**KIRKLEES METROPOLITAN COUNCIL  
INVESTMENT & REGENERATION SERVICE**

**DELEGATED DECISION TO DETERMINE PLANNING APPLICATIONS**

Reference No:	<b>2024/62/90925/E</b>
Site Address:	114, Hunsworth Lane, Hunsworth, Cleckheaton, BD19 4DP
Description:	Raising of roof height and erection of extension to roof to create first floor living accommodation, erection of first floor rear extension and alterations
Recommending Officer:	Jennifer Booth

**DECISION – CONDITIONAL FULL PERMISSION**

**Project No:** D2314      **Scale:** as noted @ A1  
**Dwg No:** PL05      **Date:** Mar 2024  
**Revision:** -      **Drawn:** TEC

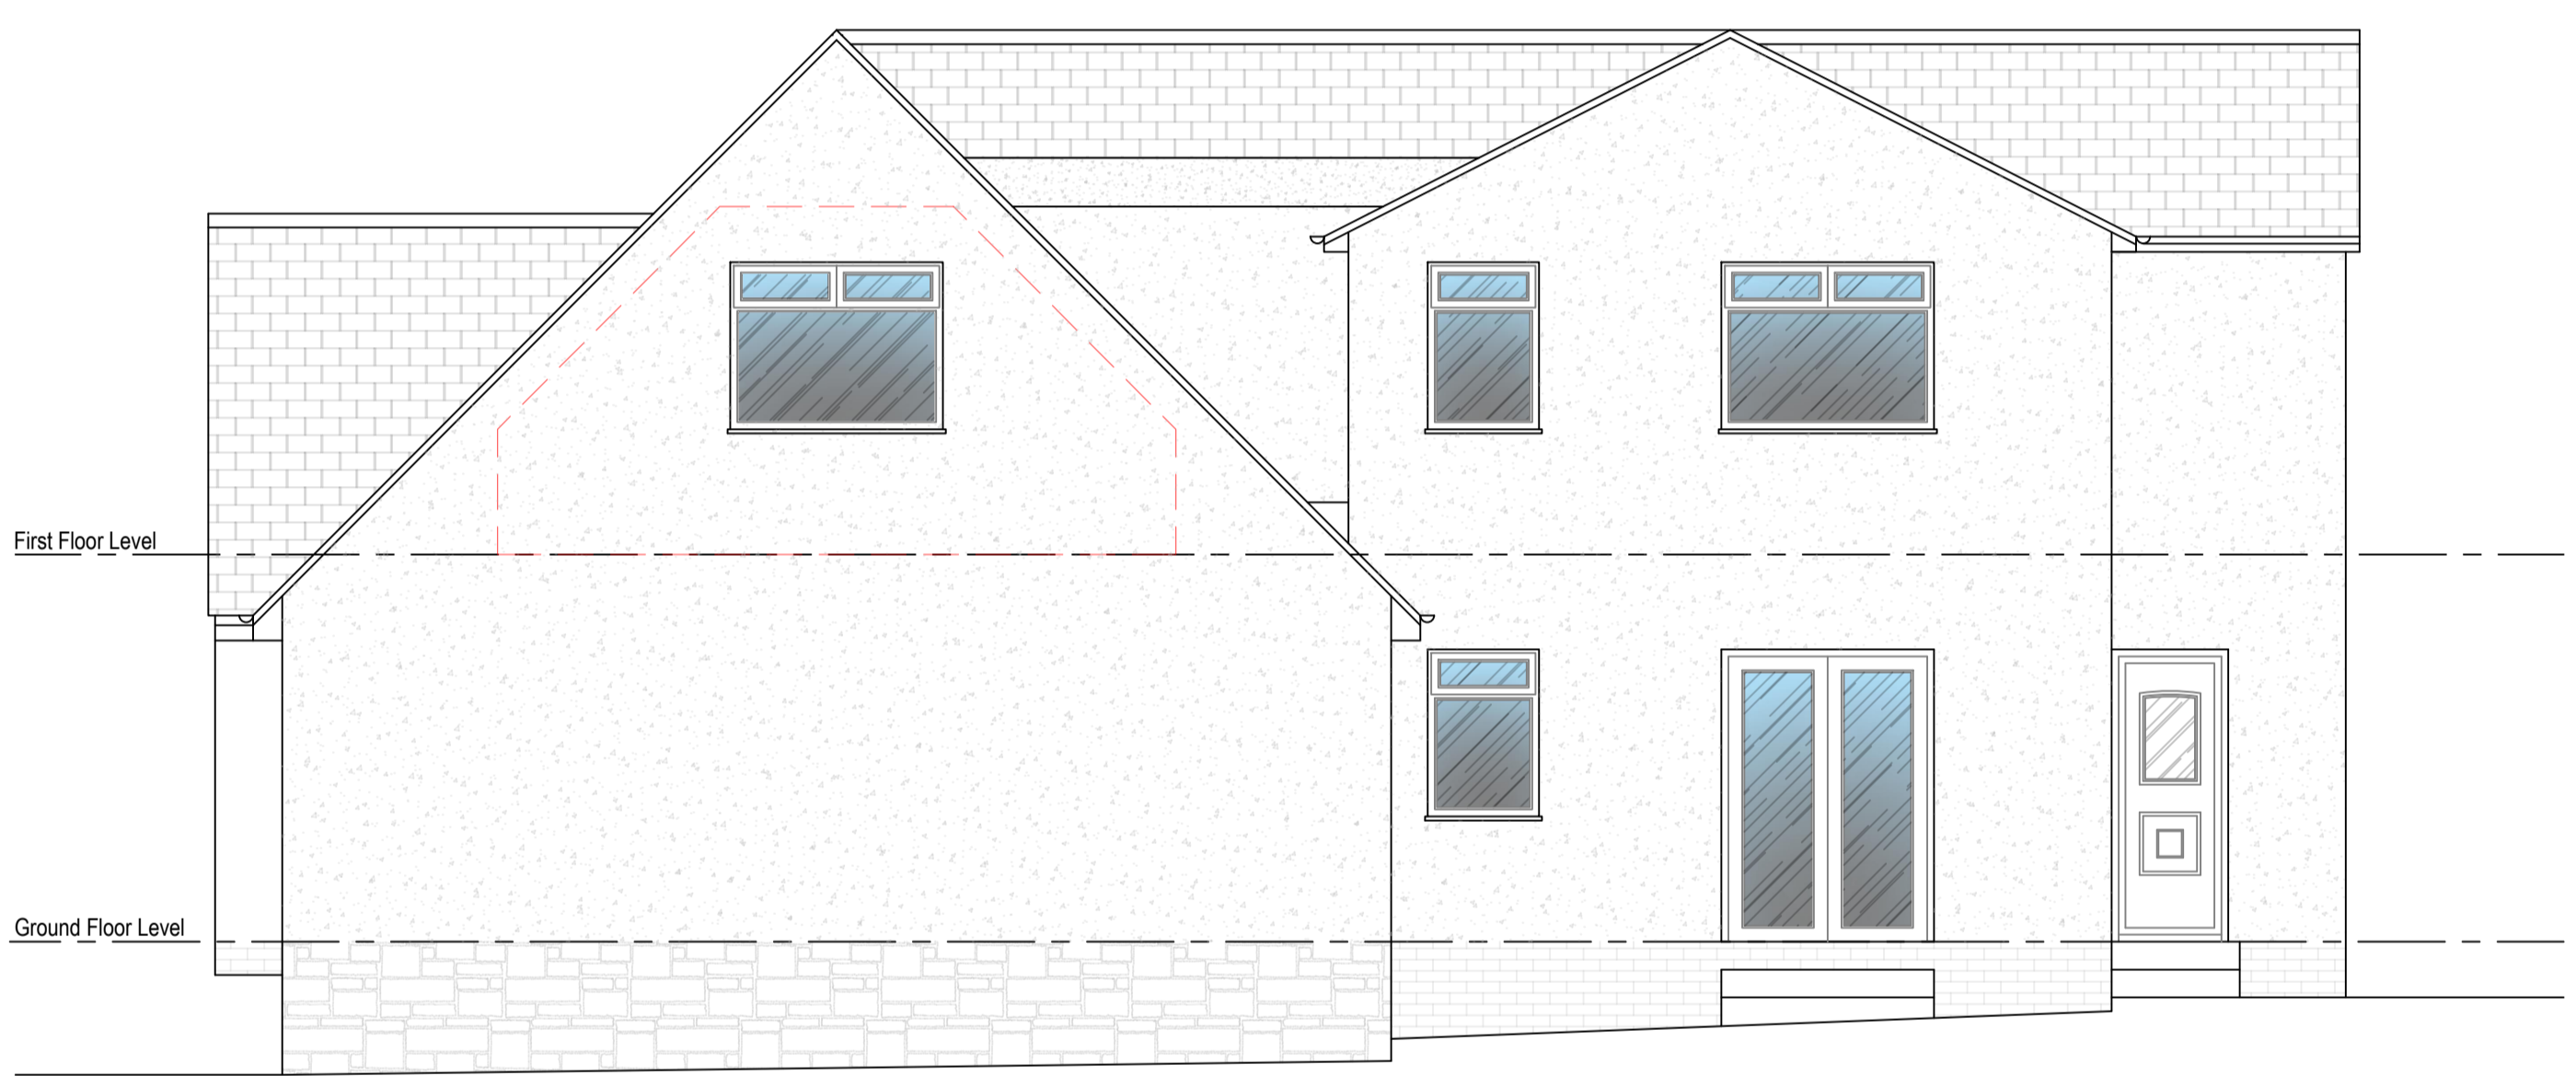
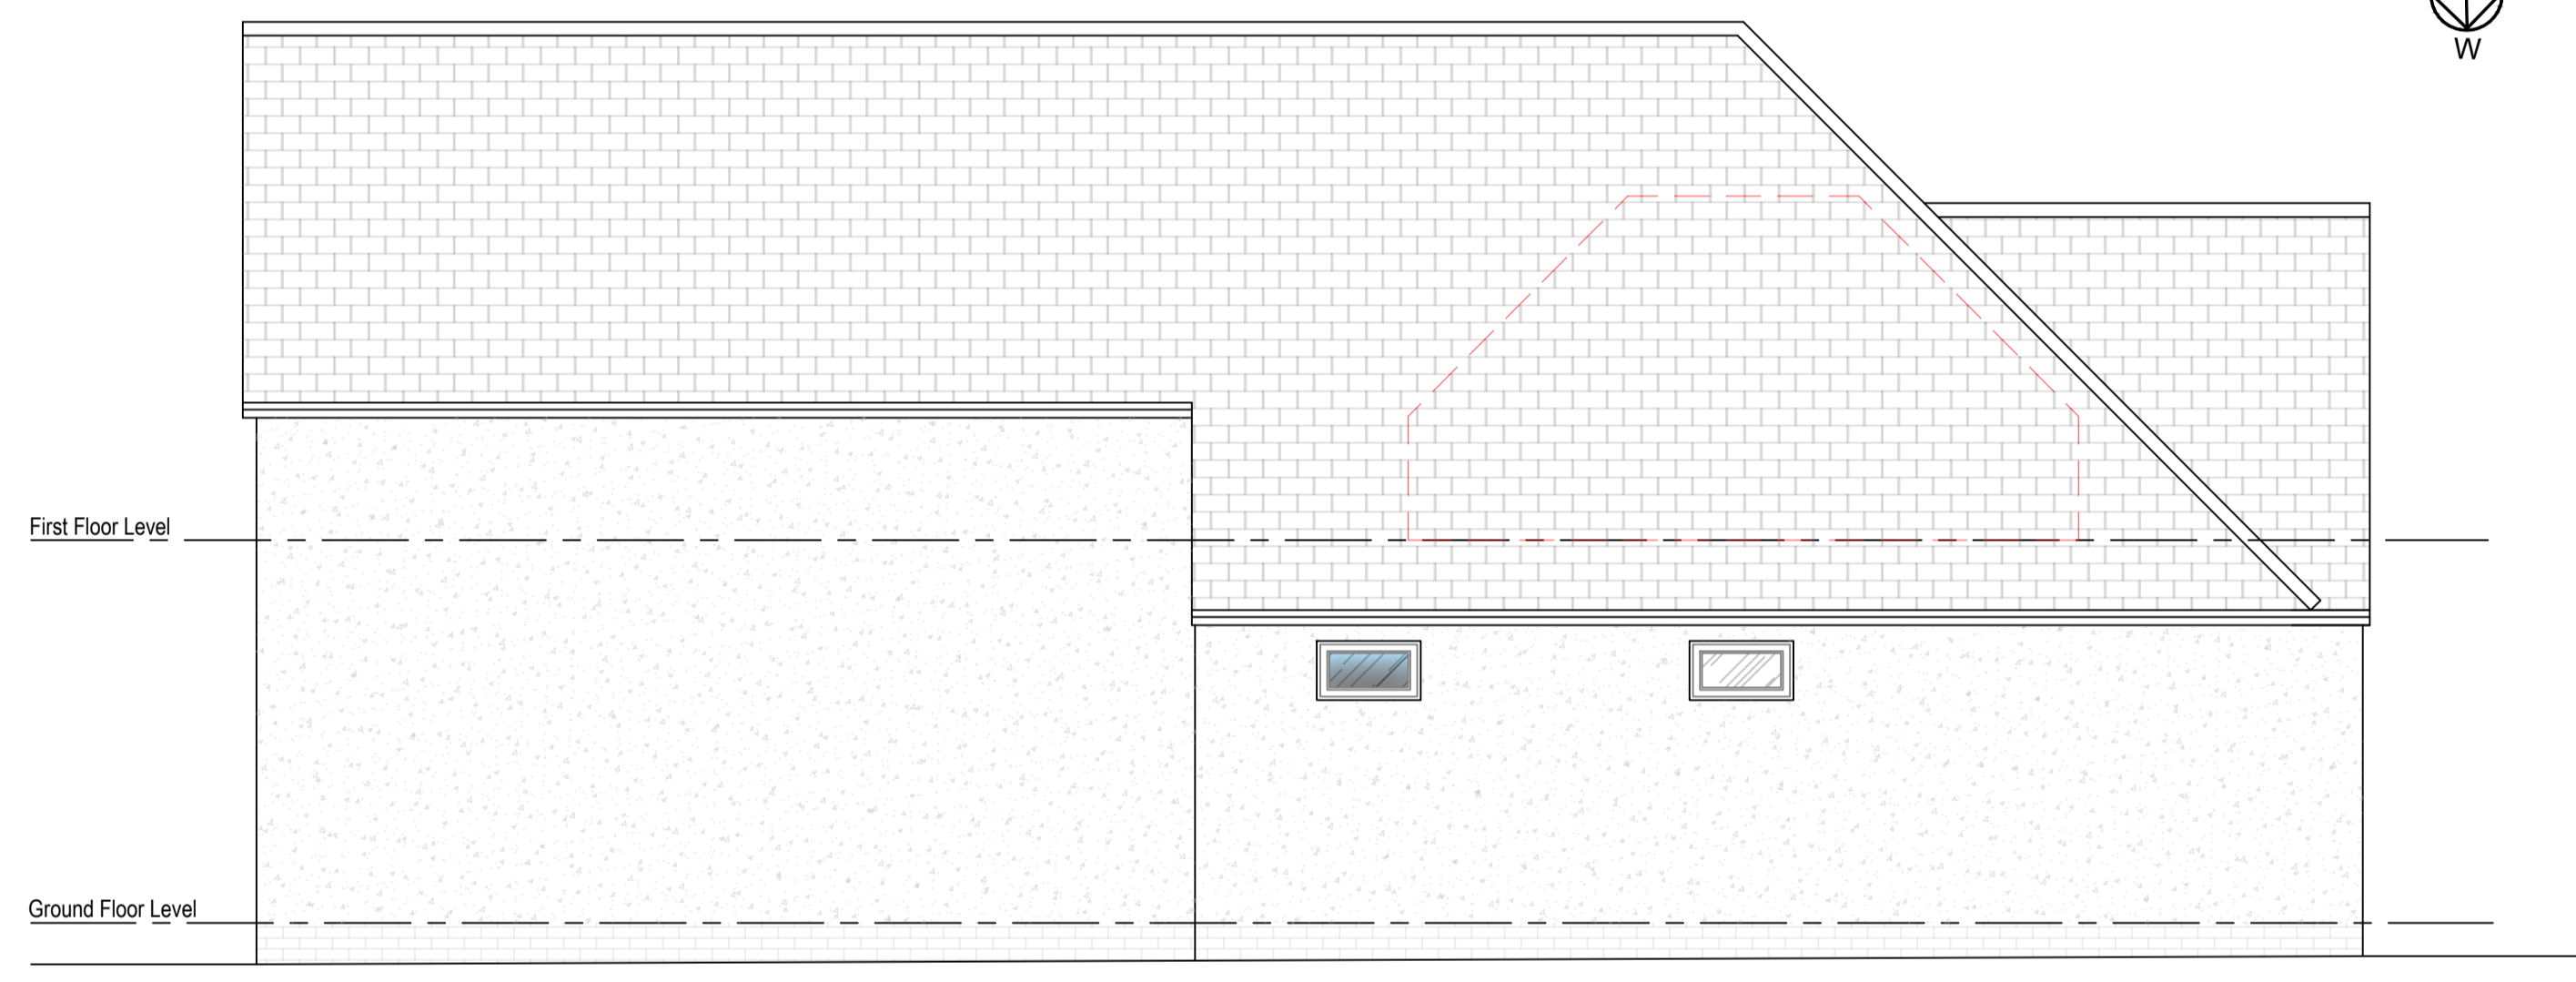
The footprint of the property would not be increased. The eaves would be carried across the front of the property at the same level, bringing the extension in line with the original. The hipped roof would be altered to a gable with an increase in height to match the apex of the two storey extension. The first floor rear extension would be built over the existing terrace.

The plinth would be a combination of brick and stone with render for the walls and tiles for the roof covering.

The proposed alterations to the house in terms of increasing the height of the property and extending first floor at the rear would not be considered to be subservient to the original house. However, in this instance, this can be considered to be justifiable given the mix of styles of properties in the area, the overall enhancement in the appearance of the main house – which is an odd looking amalgamation of previous extensions and the separation between the host property and the surrounding development. As such, the increase in height, alteration of the hipped roof form to a combination of gabled roof forms can be considered to be justifiable. The use of render for the main finish of the dwelling would form an appropriate relationship with the wider area given the mixed palette in the surroundings. A condition regarding the colour should be included and an off white finish is suggested. The alterations and extensions

The render finish should be conditioned to be an off white colour to ensure that the extensions harmonise within the street scene.

3. The external walls of the extension hereby approved shall be finished with an off white render.
